TfNSW reference: WST24/00121 | SF2024/064488

SSD-30448824 – Junction Rivers Wind Farm – EIS Exhibition – Various Lots – Balranald-Moulamein Road, Kyalite - Murray River LGA

Attachment 1

TfNSW requests the revision of the Traffic Impact Assessment (TIA) prepared by UMWELT Consulting and RJA Route Survey Port Adelaide to Junction Rivers WF to address the following:

Figure 2 - Blade Diagram Swept Path (100 Metre blade case study)

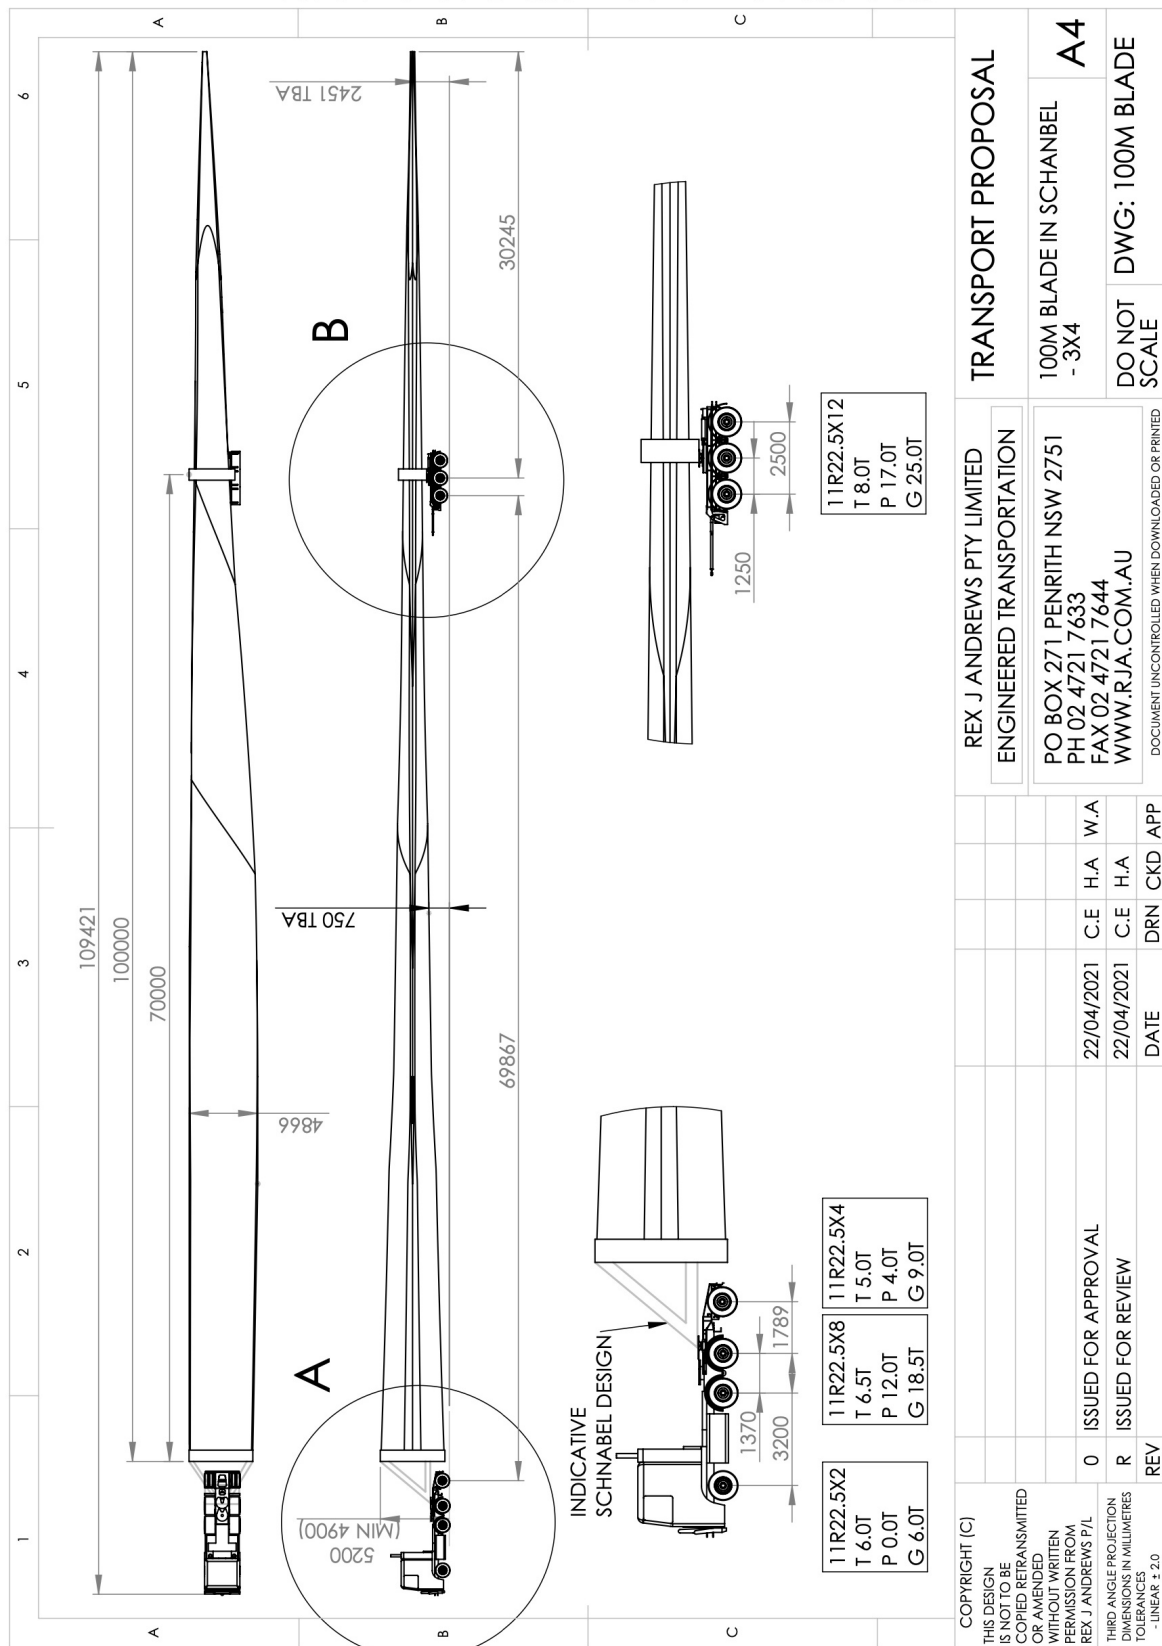
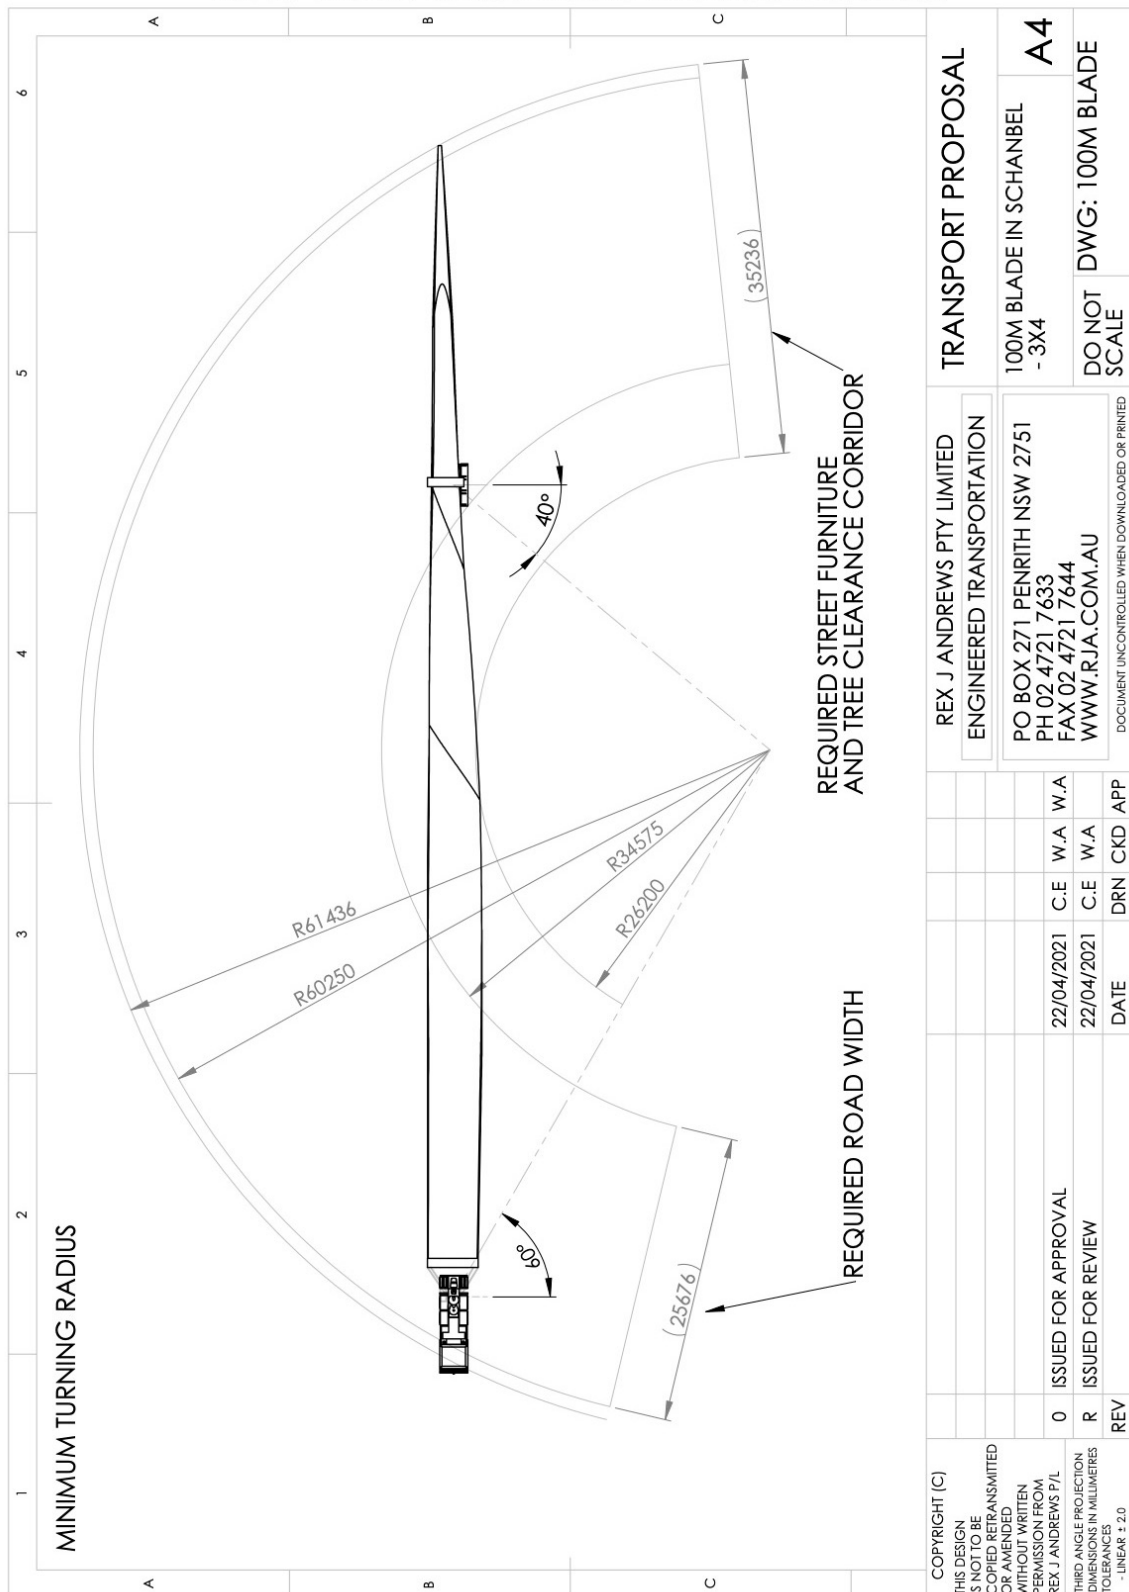
1. The configurations of the OSOM are required to be included within the revised high-risk OSOM Route Study. A conservative assessment of vehicle configurations and components should be considered to ensure the final high-risk OSOM vehicles will need to fit within the parameters set out in the route assessment.

2. Emergency parking locations have been identified in the Route Study however appear inadequate. A Number of these stops state that 90m in length is available, however the blade OSOM vehicles are up to 110m long. The OSOM route assessment must be revised to include locations of pull-over bays, laybys, and emergency stopping on the route and identify types of high-risk OSOM that will utilise each facility.

3. A swept path analysis for the largest high-risk OSOM vehicle demonstrating the largest high-risk OSOM can physically enter, exit, and park within a rest area or pull over locations without impacting access and parking for other vehicles permitted to access these locations.
